Preliminary Plat Approval

I recommend including the following conditions of approval in the staff report:

PRELIMINARY SHORT PLAT

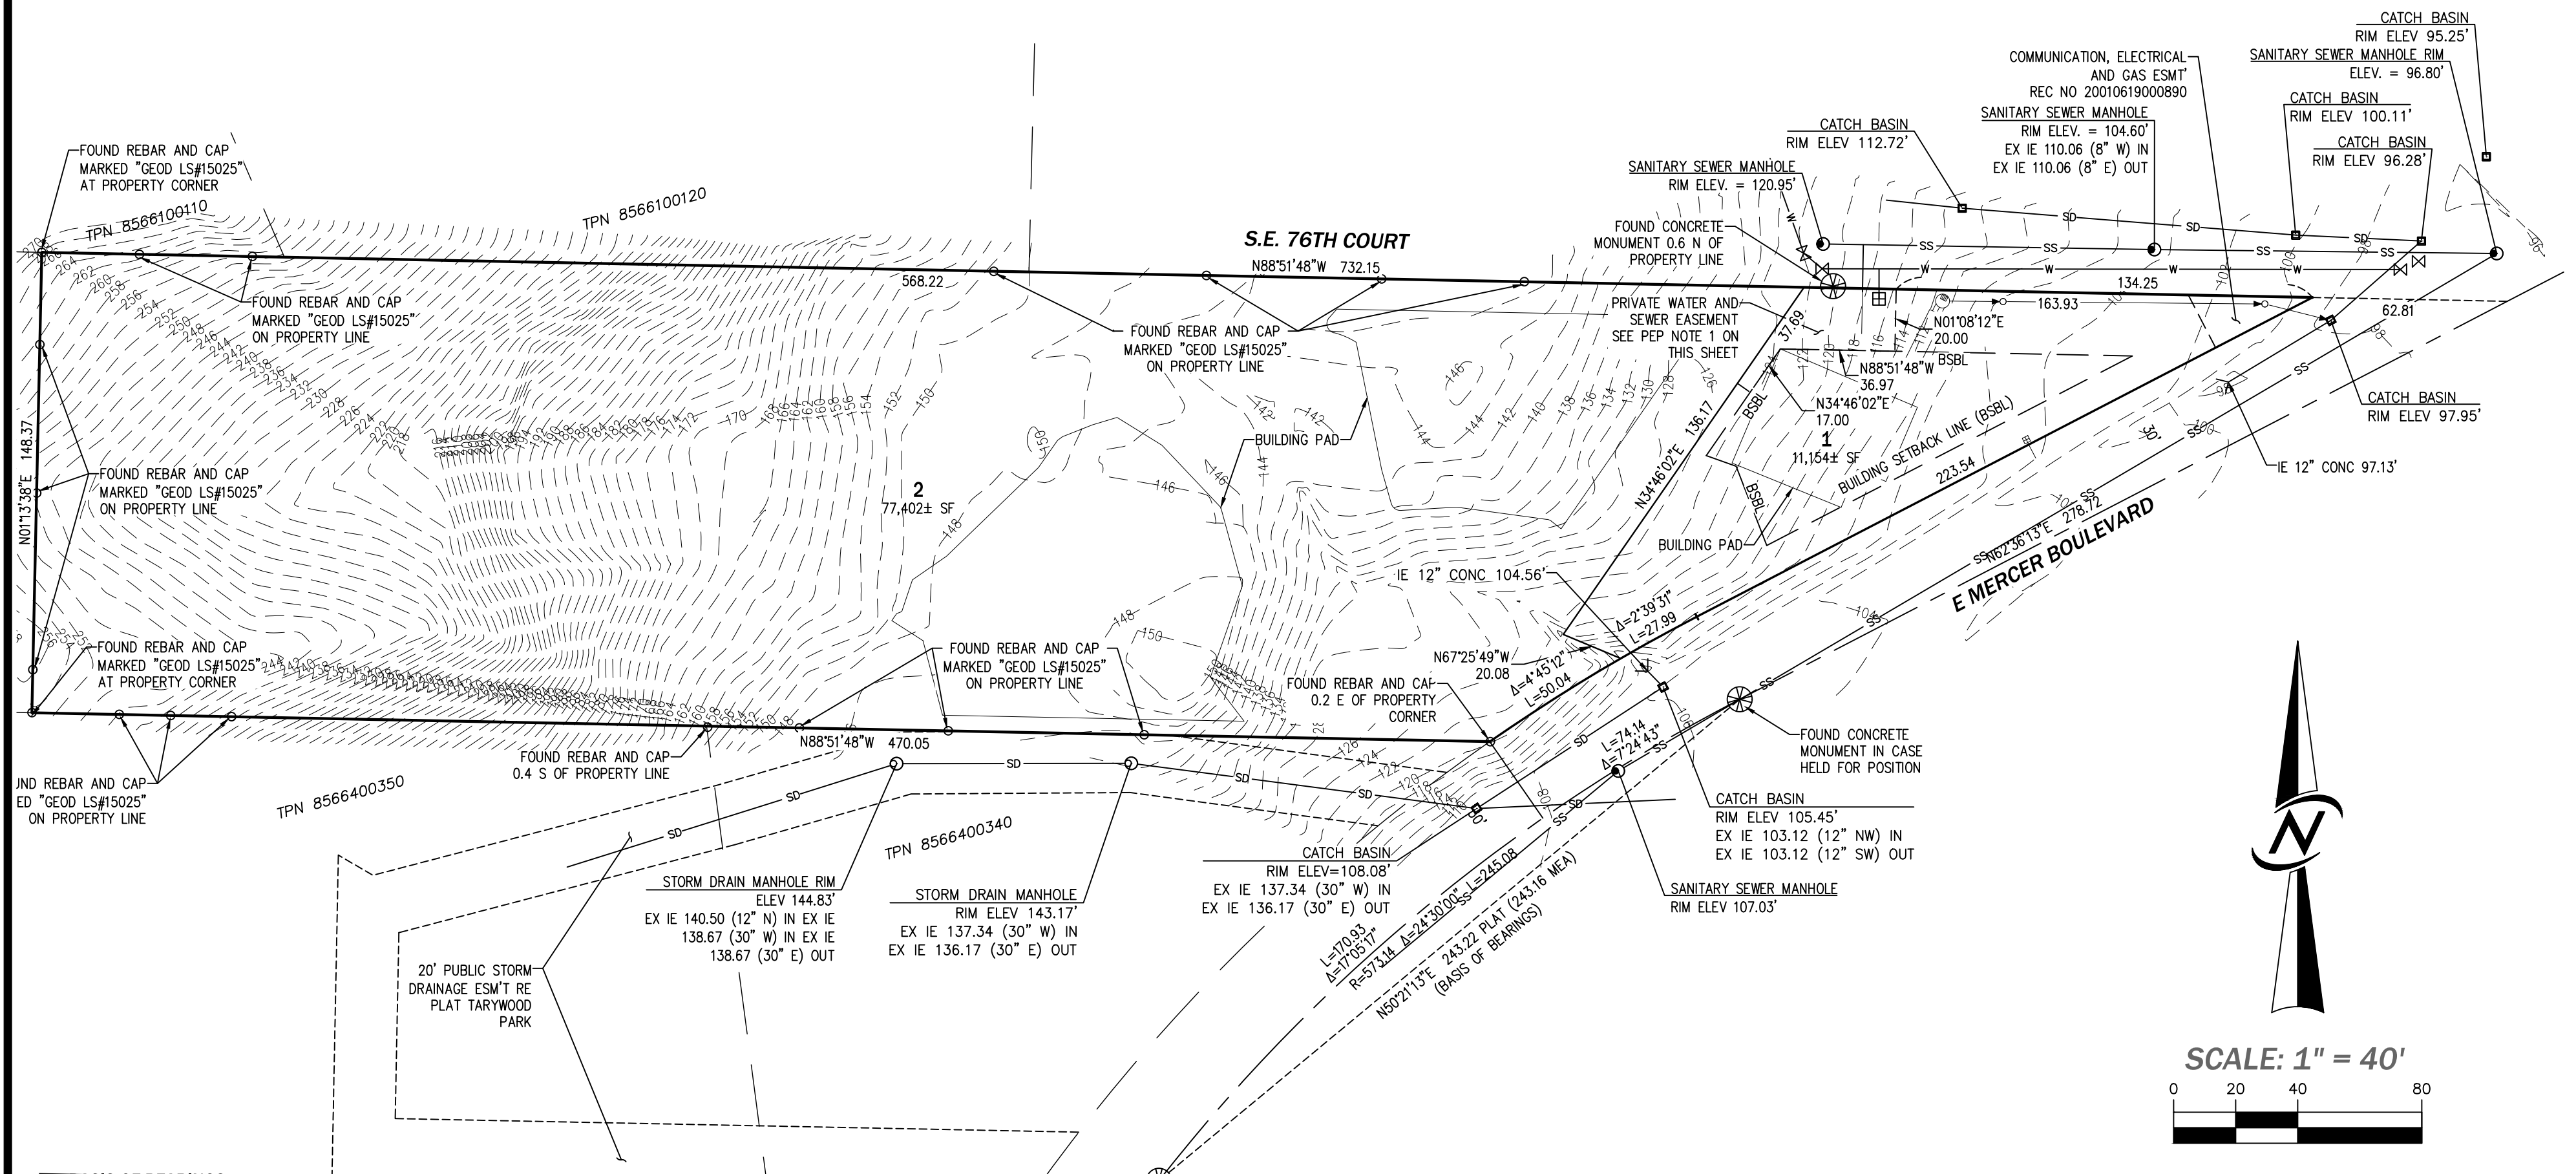
1. The plan showing numbered retained trees and building pad will be recorded as part of the plat. This plan should be the same or consistent with the Preliminary Tree Plan.
2. No tree identified for retention may be removed unless otherwise approved by the City arborist.

ROAD, GRADING & STORM DRAINAGE PLAN
CHESHIRE SHORT PLAT

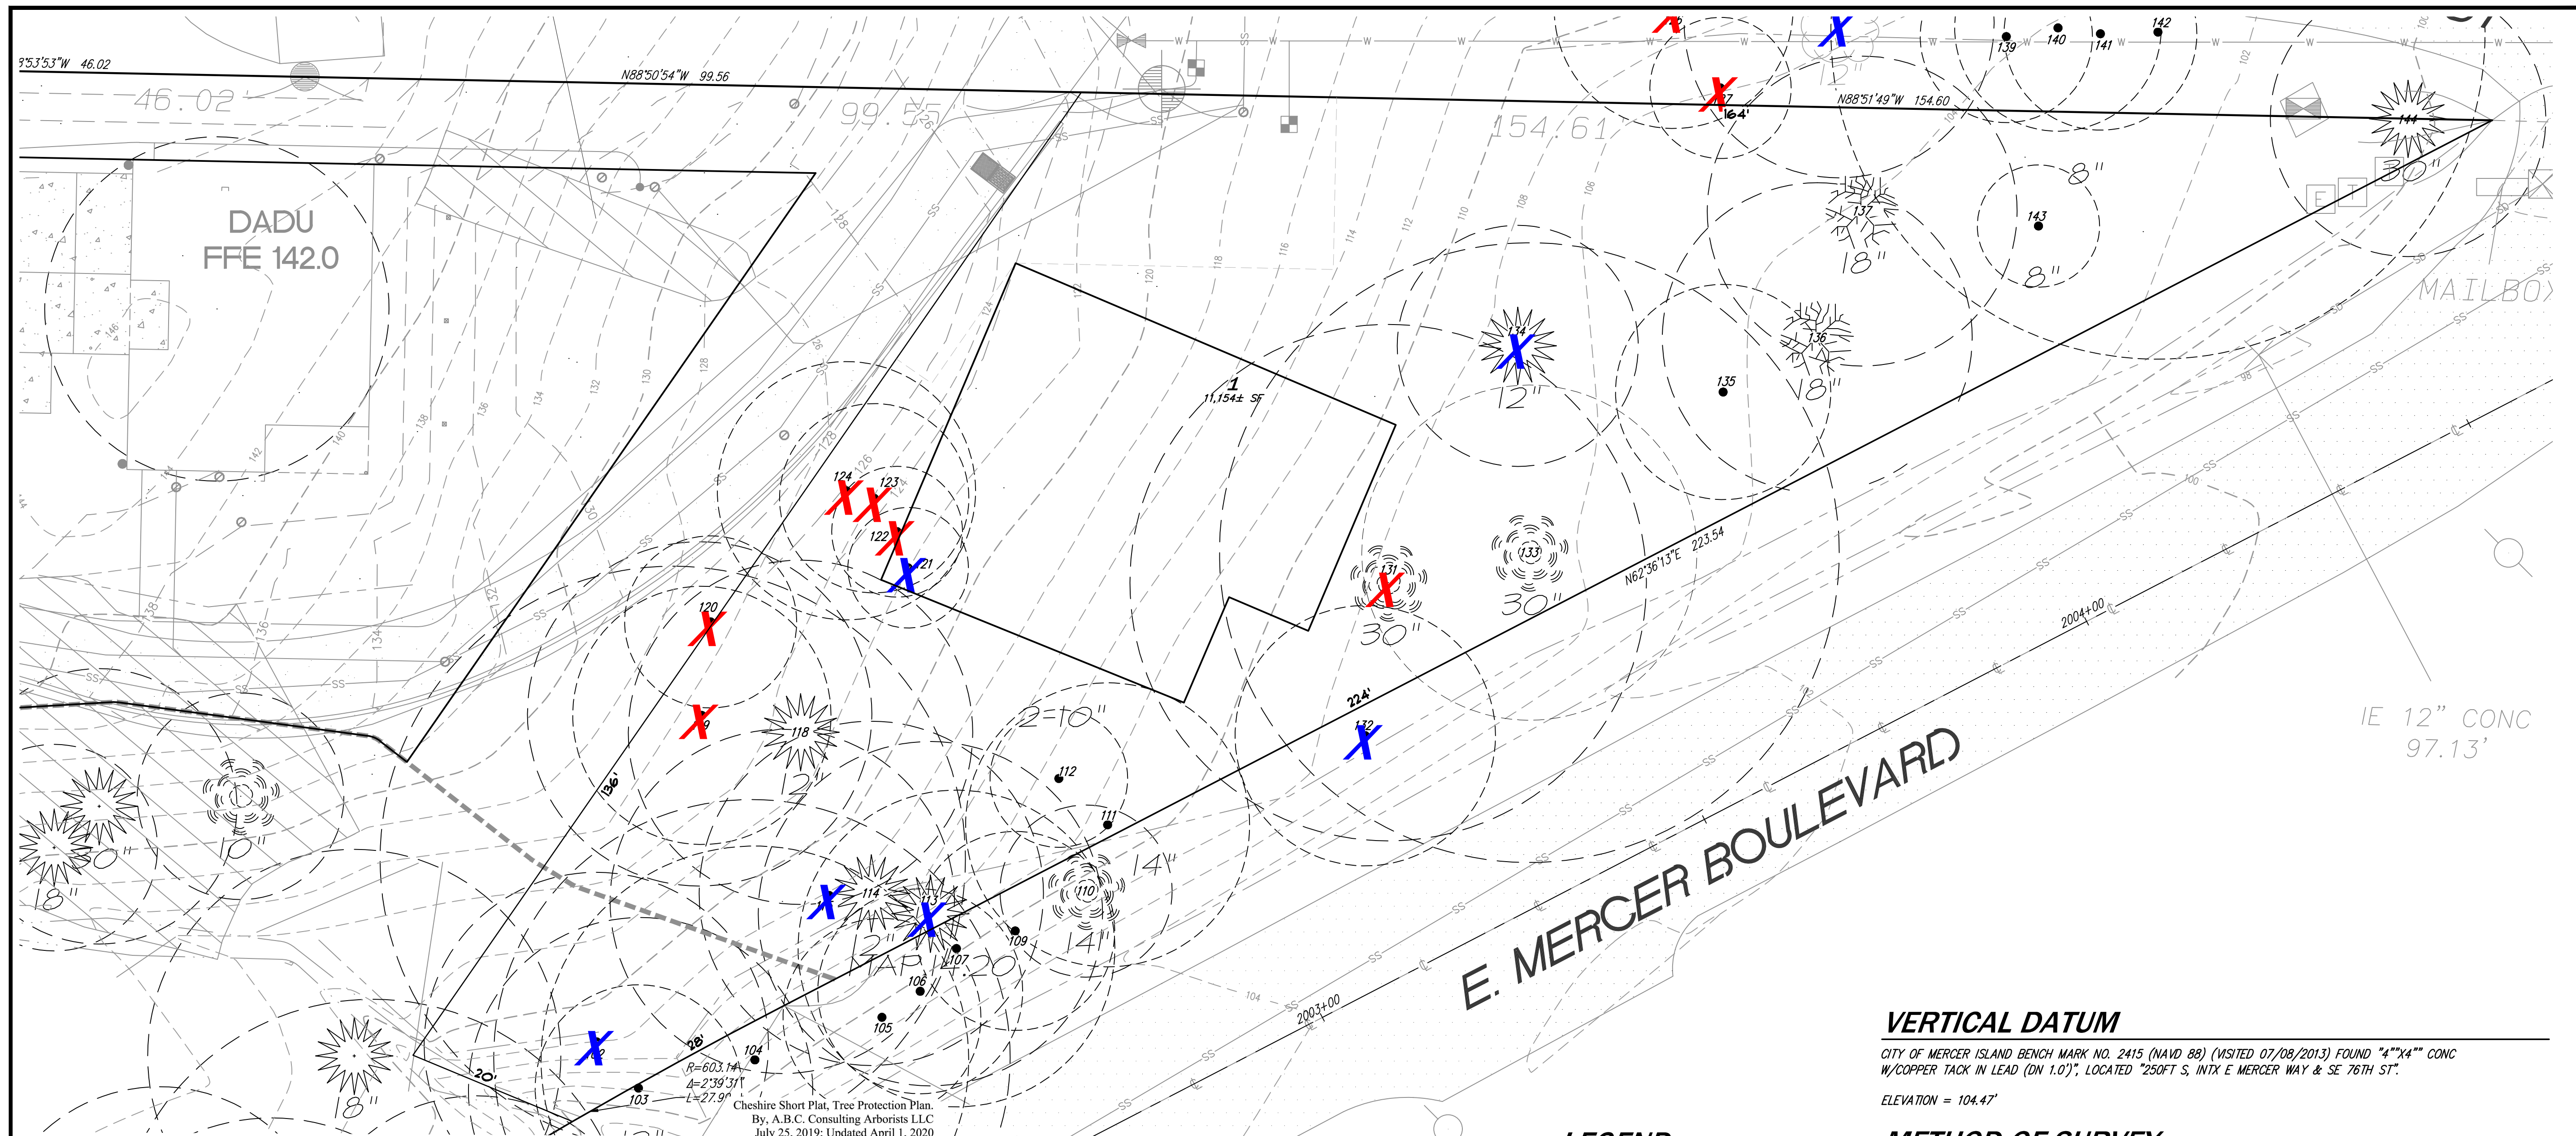
1. A tree replacement plan will be provided under the building permit application. It will follow the requirements described in 19.10.070.
2. A tree protection plan will be submitted during building review. Showing tree protection fencing at the Arborist stated tree protection zone (TPZ). For tree 133 tree protection may be reduced to 18' to the west or the critical root zone (CRZ). This distance must be called out (near building pad) and the tree protection fence shown on the plans. The building pad including over excavation for a foundation shall not encroach into this CRZ.

3. The fence for tree 133 and other exceptional trees shall be 6' chain-link fence secured into the ground. This will be called out on the Tree Plan during building review.

4. Project Arborist to be on site and in control of any excavation or grading within tree 133's dripline. They will document and clean cut any root over 1" in diameter that needs to be removed. Call this out on Tree Plan during building review.

5. Proposed water meter location to be moved away from tree 133 and outside tree protection zone. Or according to the Senior City Development Engineer. Call this out on Tree Plan during building review.
